**KIRKLEES METROPOLITAN COUNCIL
INVESTMENT & REGENERATION SERVICE**

**DELEGATED DECISION FOR APPLICATION FOR CERTIFICATE OF
LAWFUL DEVELOPMENT**

Reference no.: 2025/CL/90637/E

Site: 73, Hightown Road, Cleckheaton, BD19 5JP

Proposed Site Plan

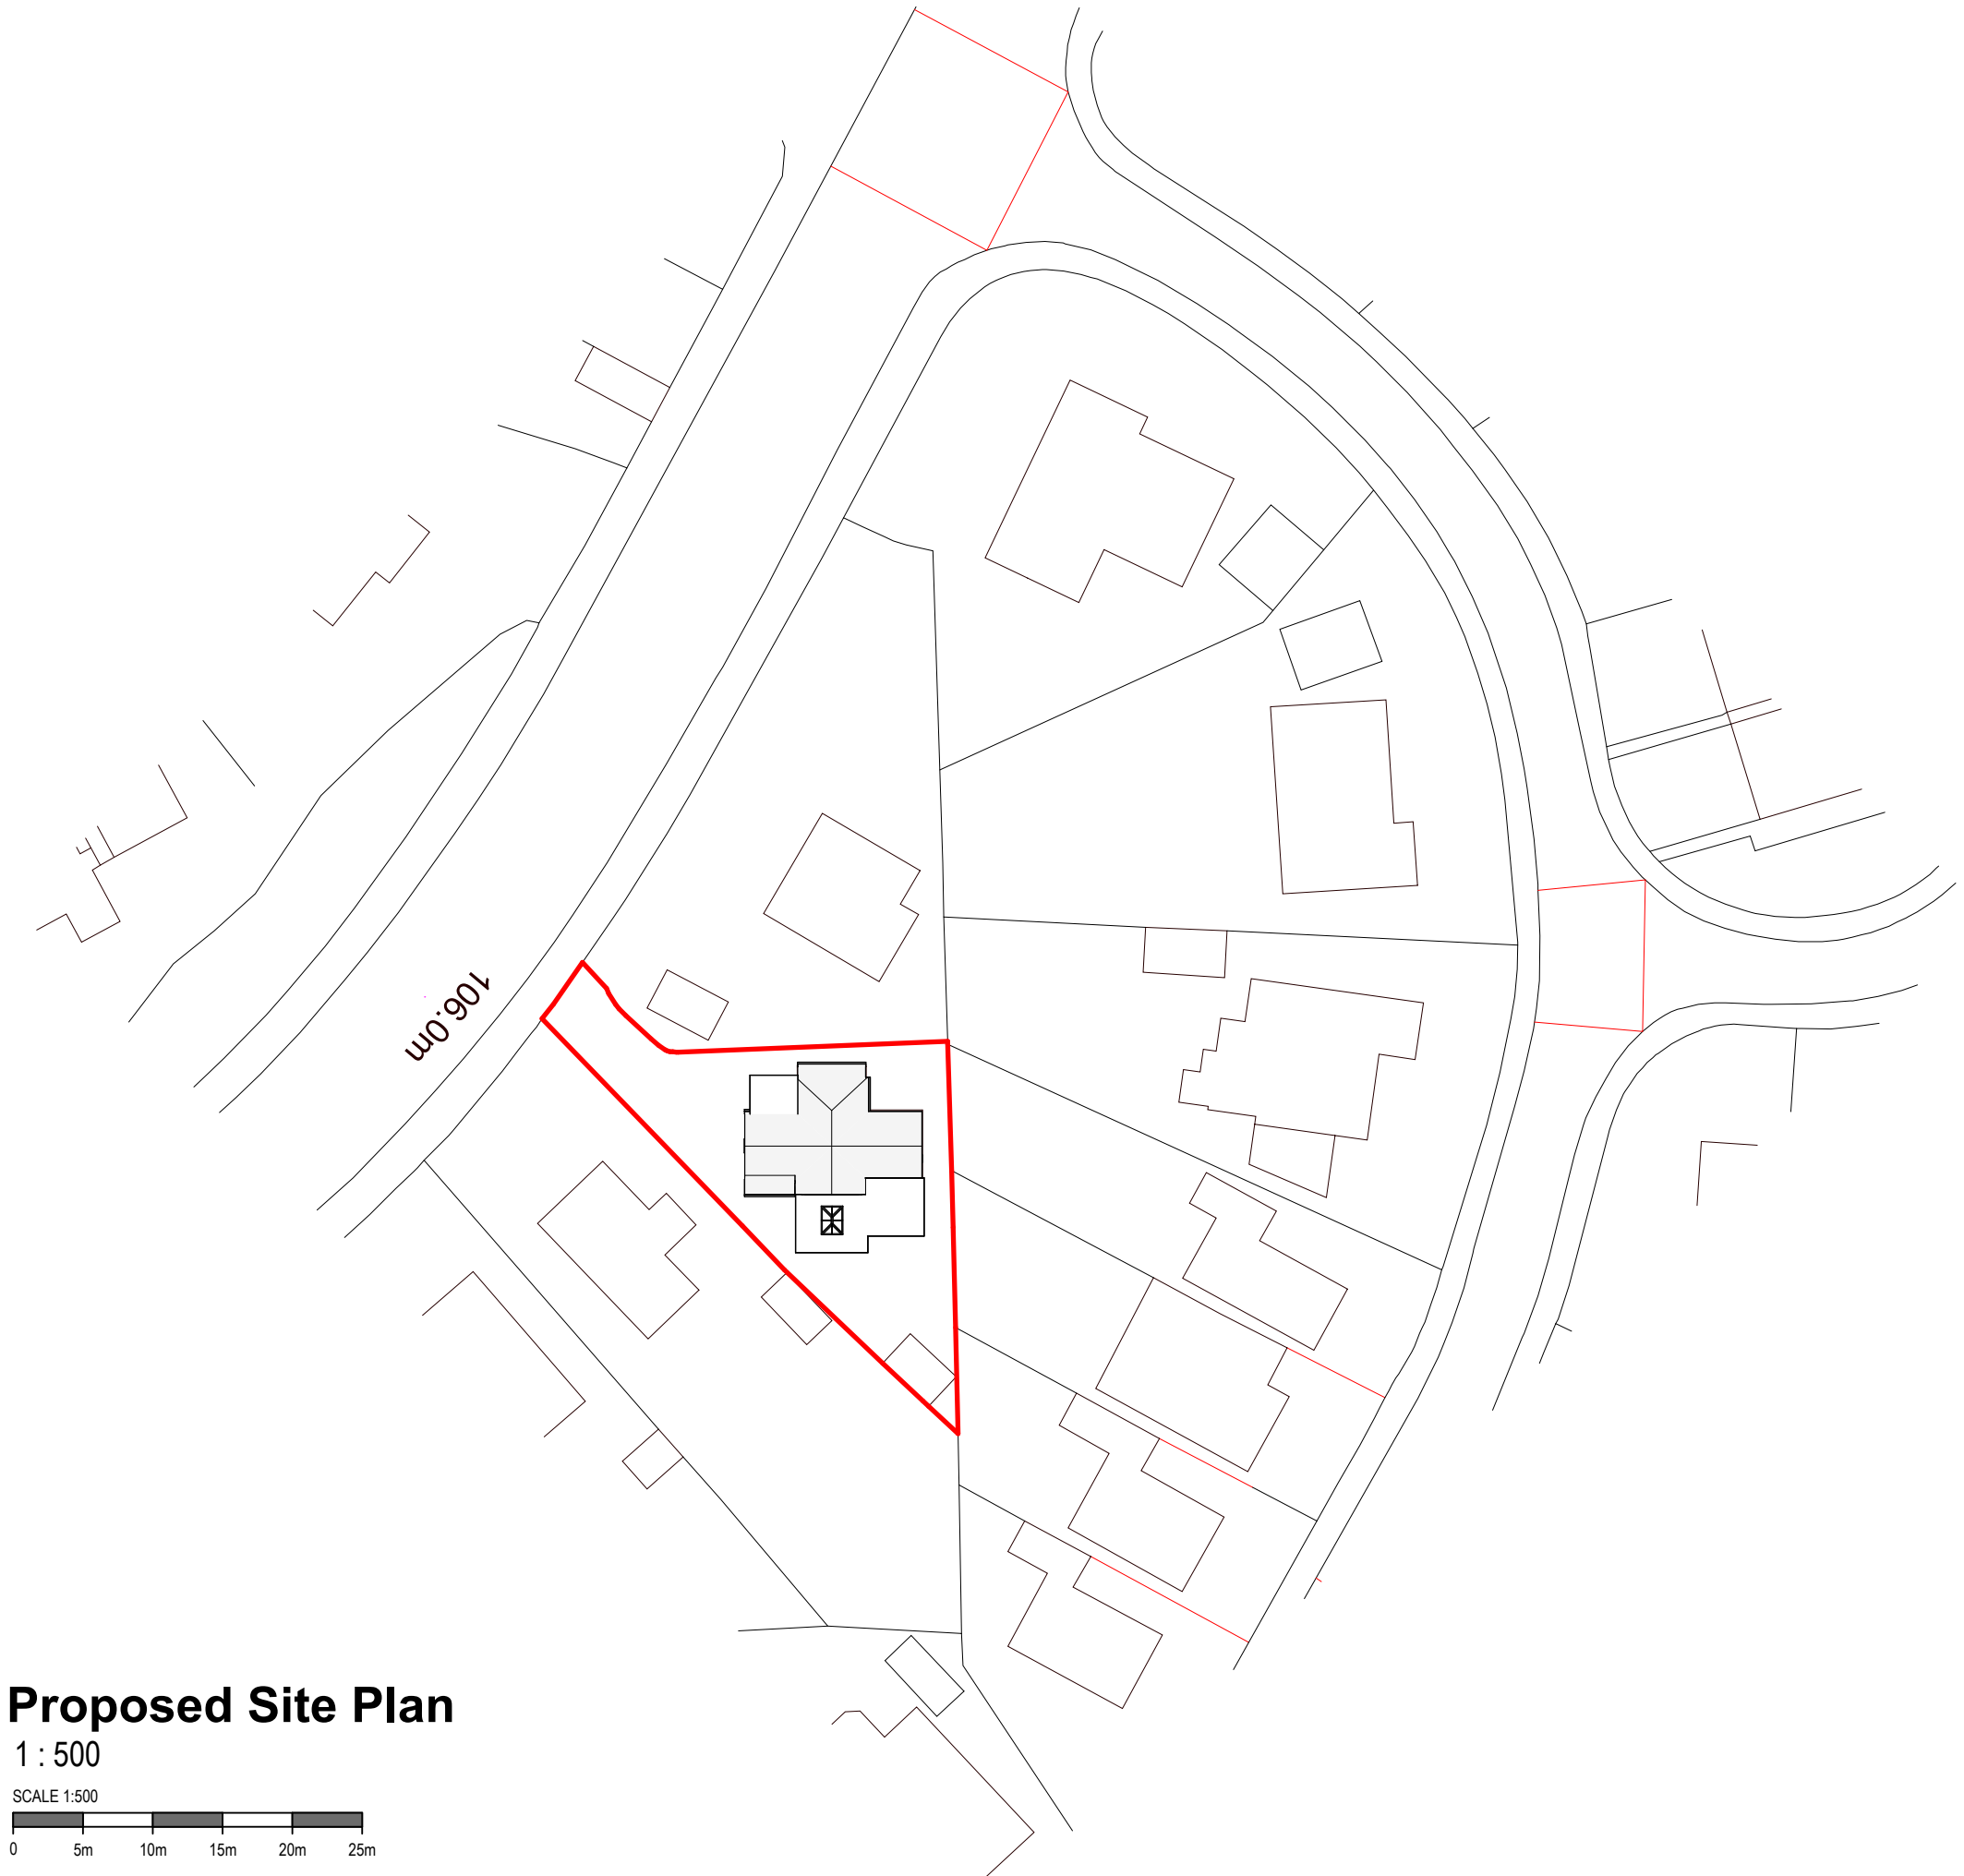
It is however noted that the submitted plans indicate that the existing glazed porch would be made solid with a new roof. This element, as shown on plan does not form part of the assessment of the application as this was not included on the description of development. It is likely that this element of the scheme would require planning permission as it appears that the structure would be forward of the principal elevation of the original dwelling.
